From: Martyn White
Sent: 21 June 2019 10:24
To: Planning.Responses
Cc: Amber Willard
Subject: AL/31/19/HH

AL/31/19/HH

I note that the application is for a Single storey rear extension, as well as replacement front windows.

Proposed Ground Floor
1 : 50

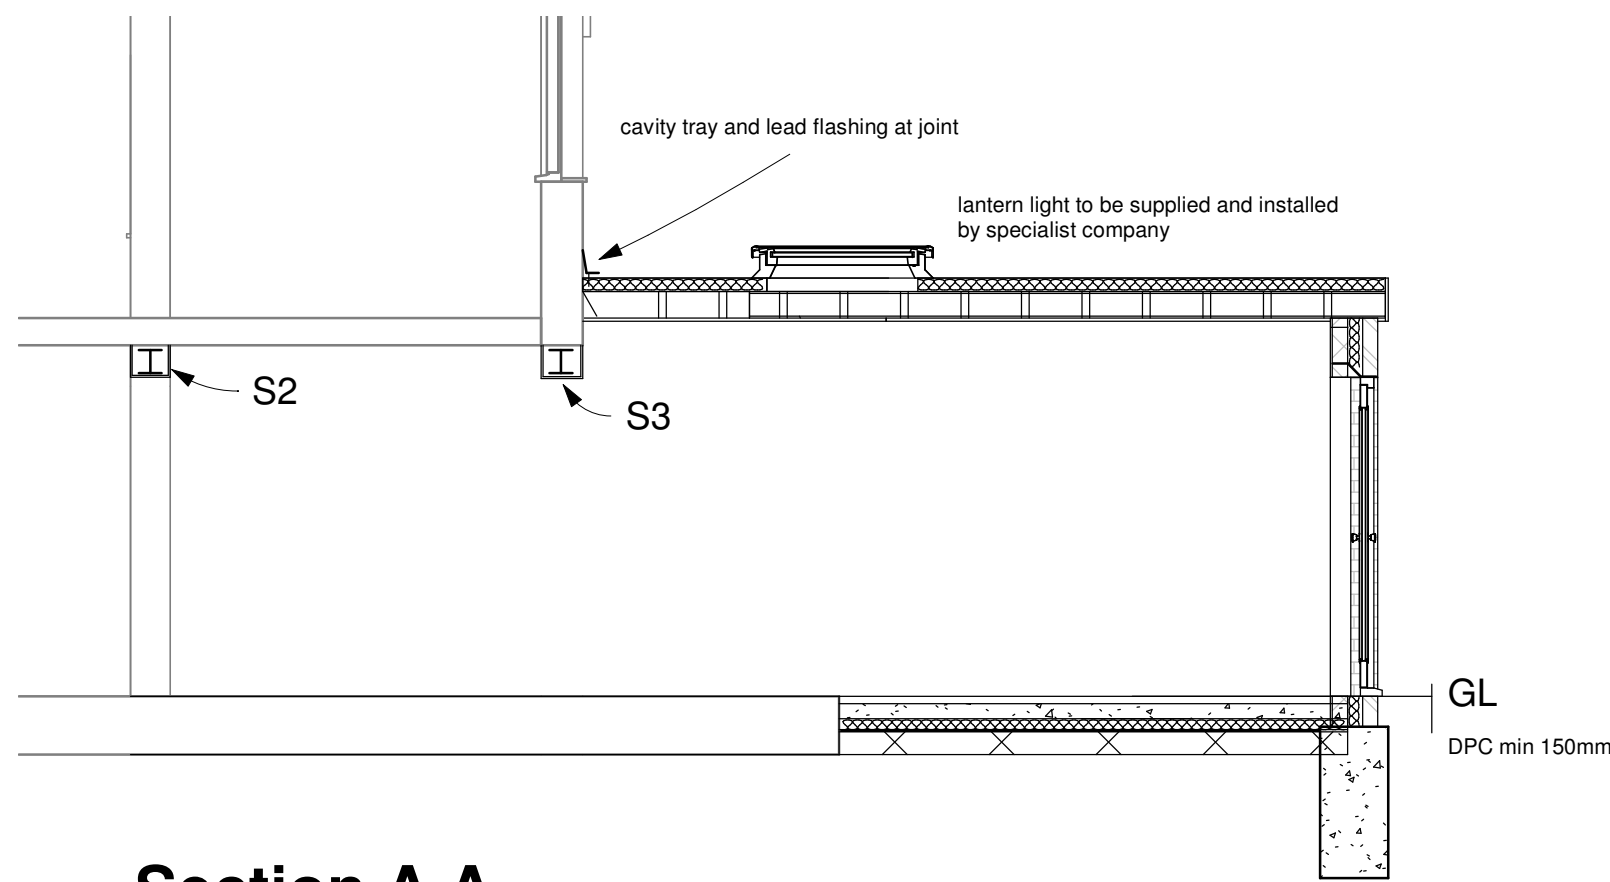
The concept of a rear, single storey extension is acceptable as it will not be seen from the public domain. The success or otherwise will depend upon the quality of the materials to be used.

Proposed Front
1 : 100

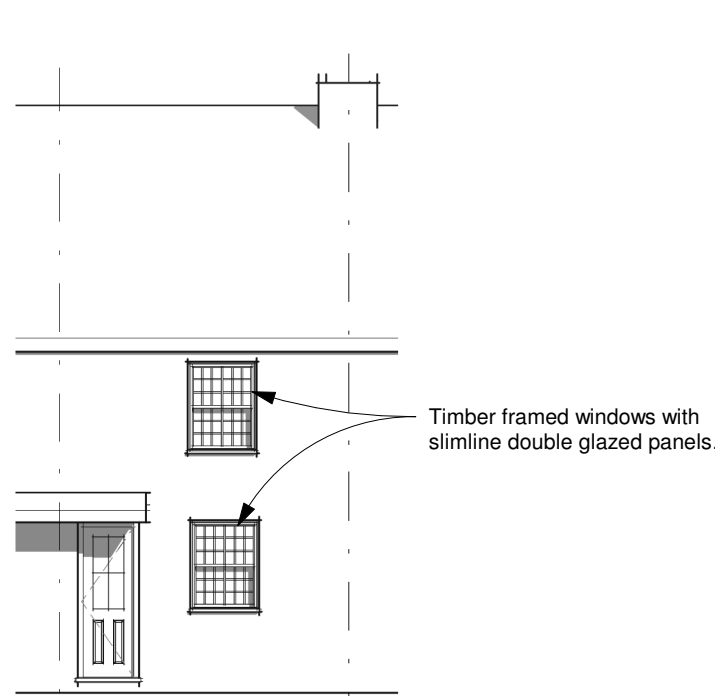
With regards to the proposed replacement windows (to the front of the building), I note that the design has been amended so that the replacement windows are now to be timber framed with slimline double glazed panels. Such a concept is acceptable, subject to the replacement windows closely reflecting the existing ones in terms of design and appearance. This could be dealt with by way of condition, where details of the existing and proposed windows are supplied to the LPA.
